SSD-9872: Lot 40 DP 756894; 48 Broadhead Road, Spring Flat; Educational Establishment (St Matthews Catholic School Mudgee – Secondary Campus)

Thank you for referring SSD-9872 to Transport for NSW (TfNSW) for comment. I note SSD-9872 has been referred to TfNSW pursuant to Clause 57 of *State Environmental Planning Policy (Educational Establishments and Child Care Facilities) 2017* (Education SEPP) and Clause 104 of *State Environmental Planning Policy (Infrastructure) 2007* (ISEPP).

TfNSW has reviewed the documentation submitted with the application and provides the following advice:

DRAWING TITLE  
**VEHICLE SIMULATION PLAN**

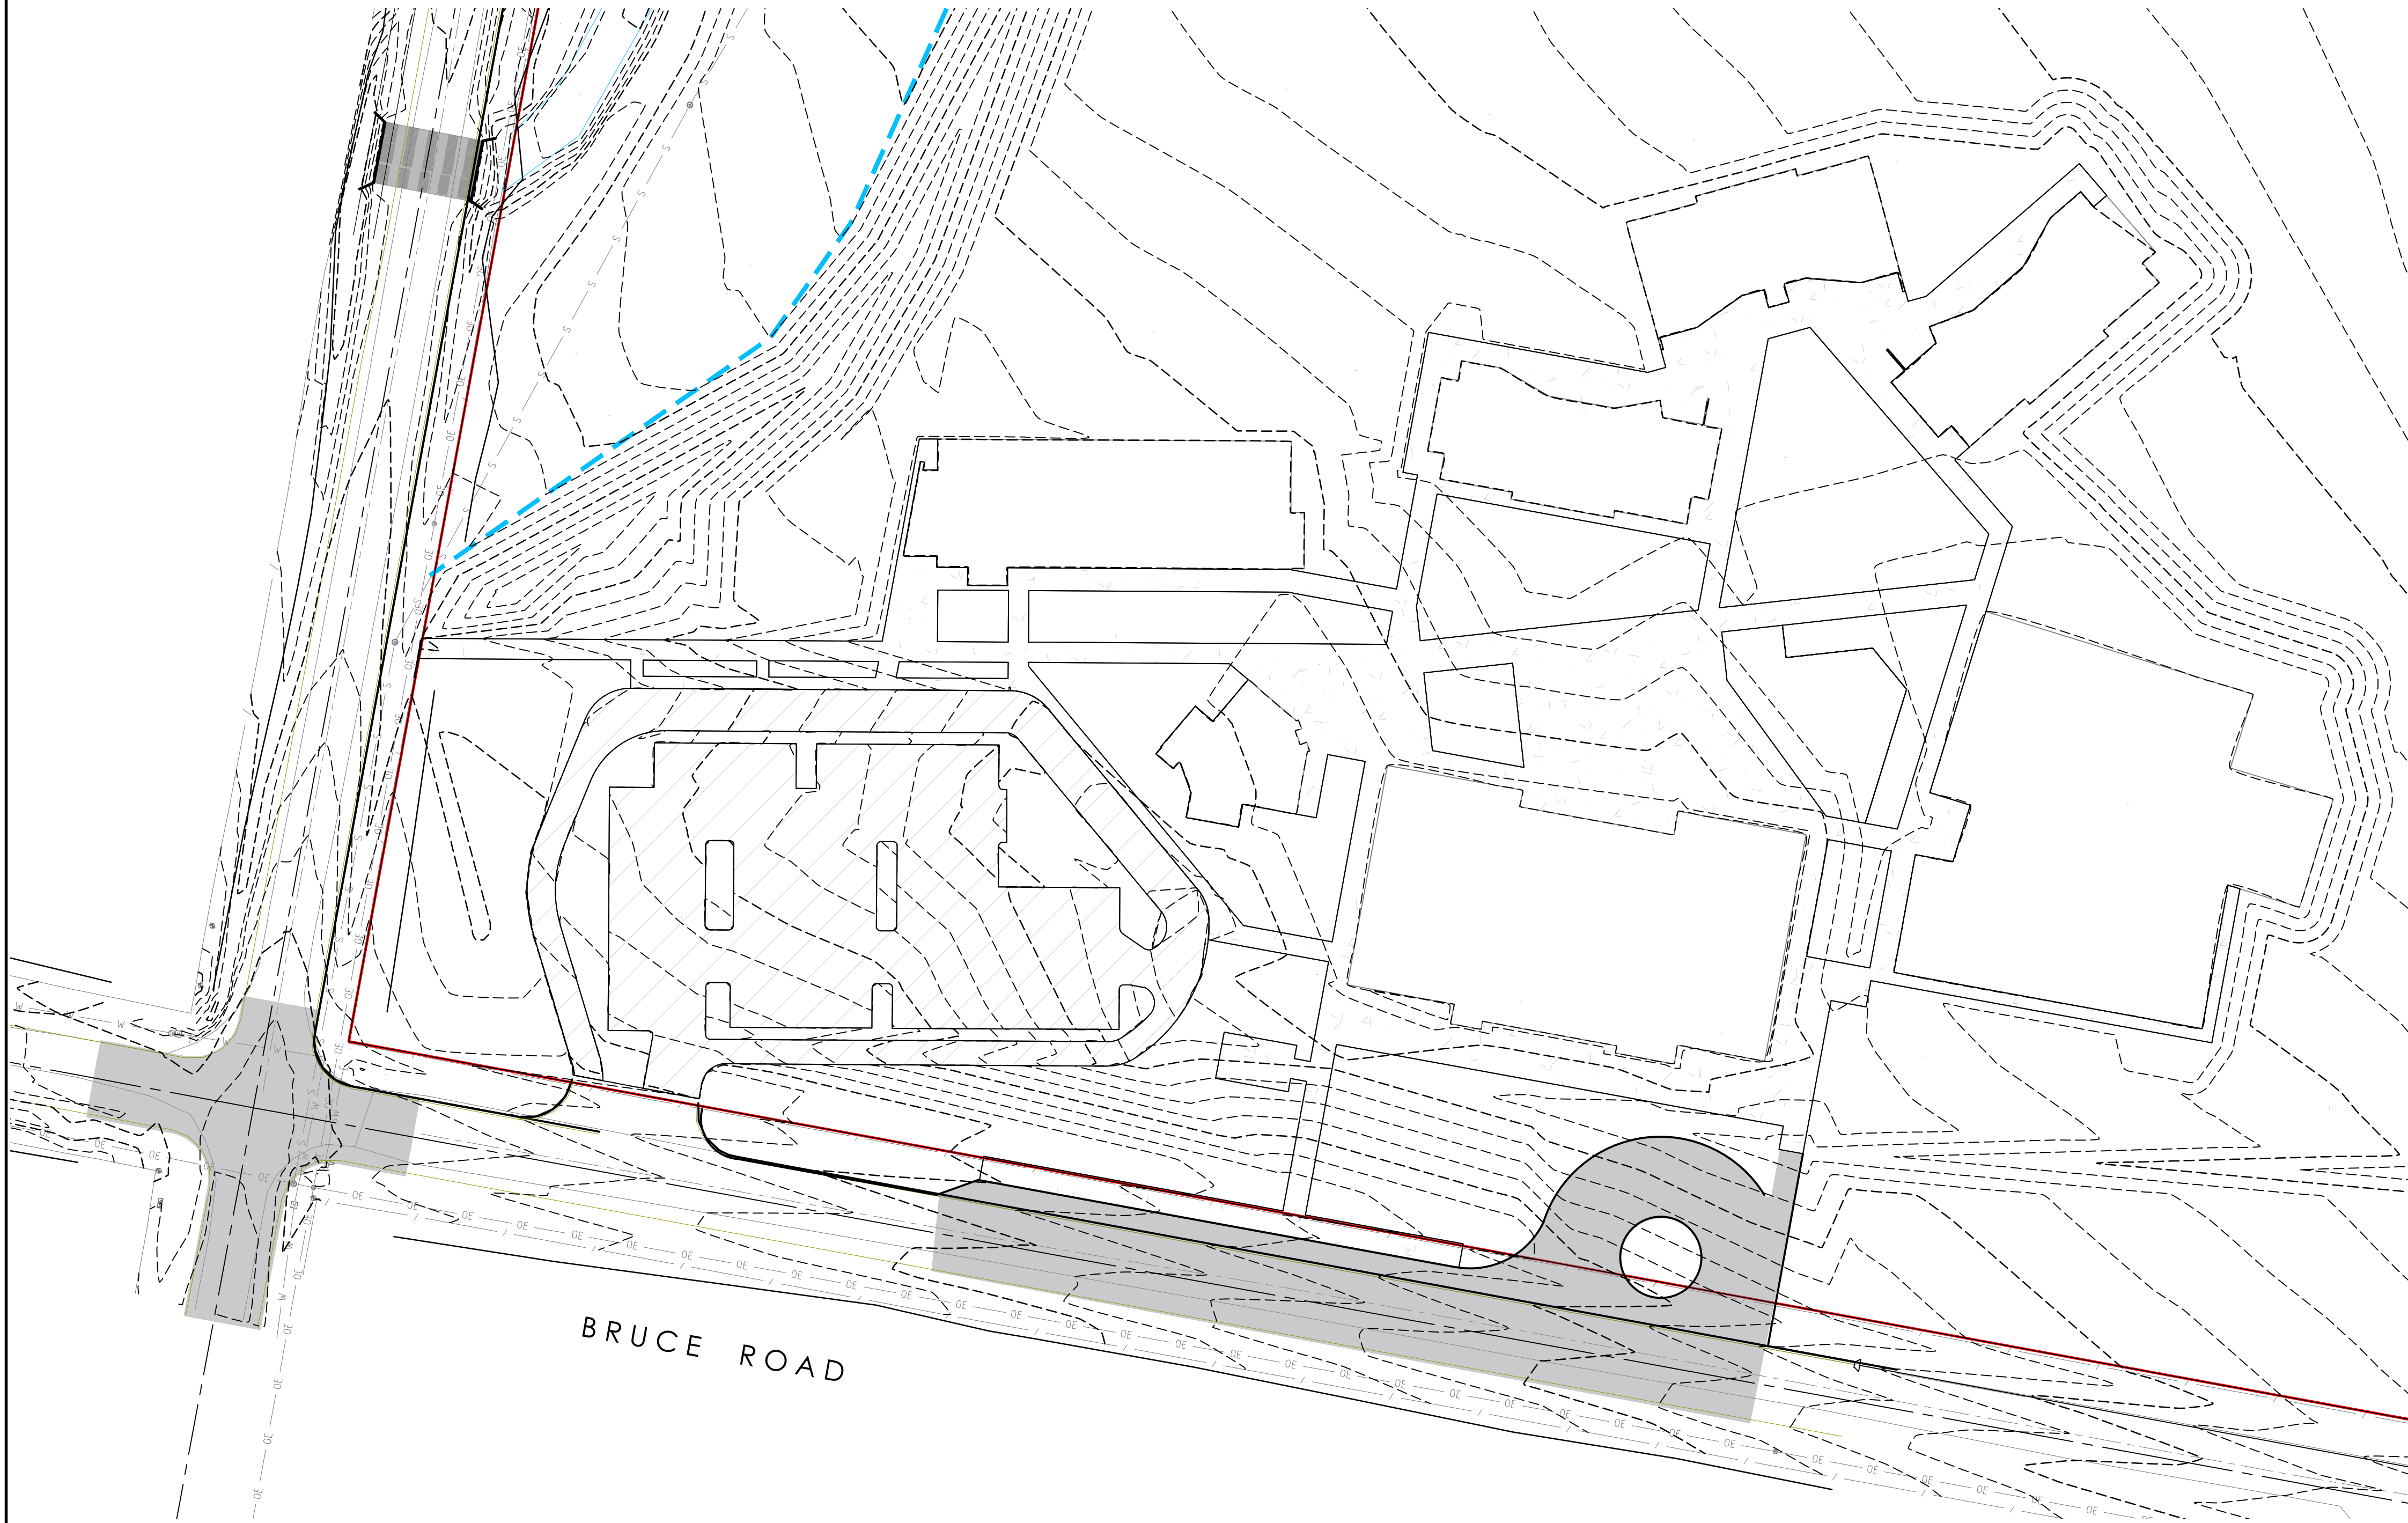
- (e) It is not clear from the information provided that buses turning left out of Broadhead Road into Bruce Road can undertake the turn movement in a lane correct manner. Swept path plans are required to demonstrate that turn movements are achievable in a lane correct manner. If the turn movements cannot be made within the correct lanes, an upgrade to the intersection to accommodate the turning movements is required.
